Subject: 70 Anderson Street Redevelopment
Comment Response Letter

Shukria Wiar – Memorandum to Portland Planning Board 7/18/16

DRAWING NO.  
**C-30**

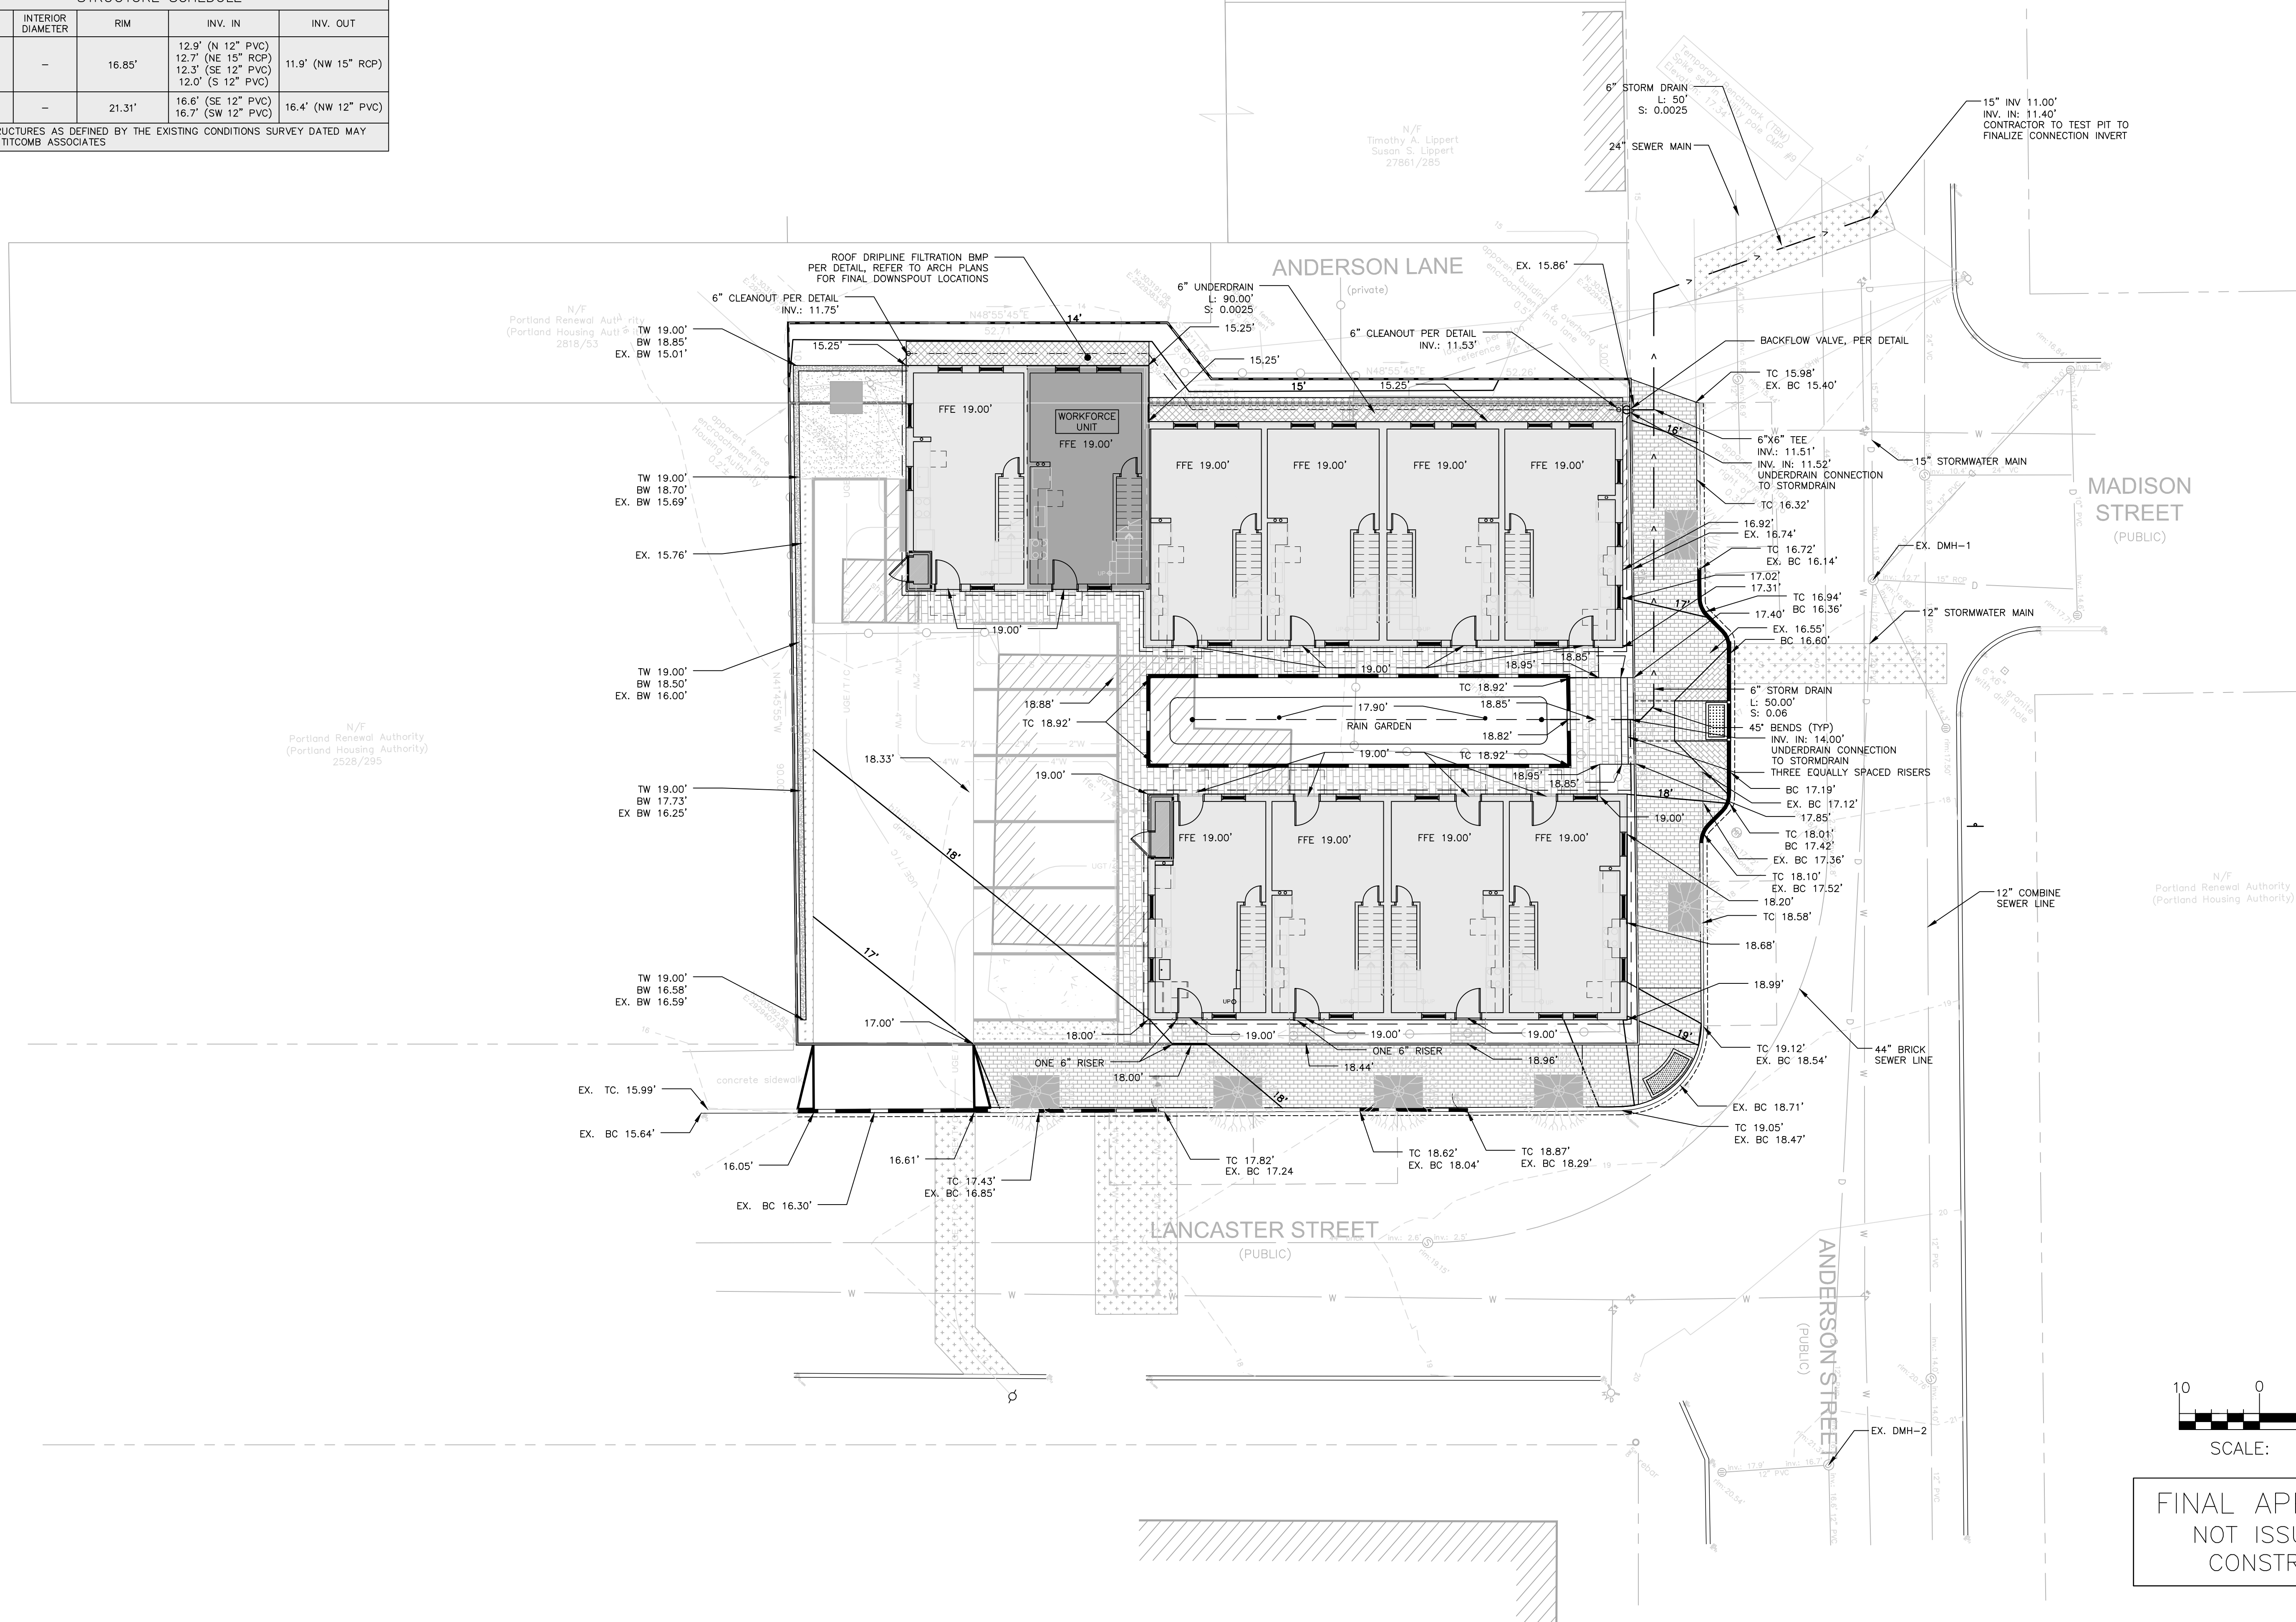
Comment – *Pavement trenching/repair in the roadway should be noted on the plan at the locations of the connections to the storm drain.*

Response – Hatches denoting the approximate and estimated extent of utility trenching within Anderson Street for the proposed stormwater outlet has been added to C-10 Site Plan and C-30 Grading & Drainage Plan.
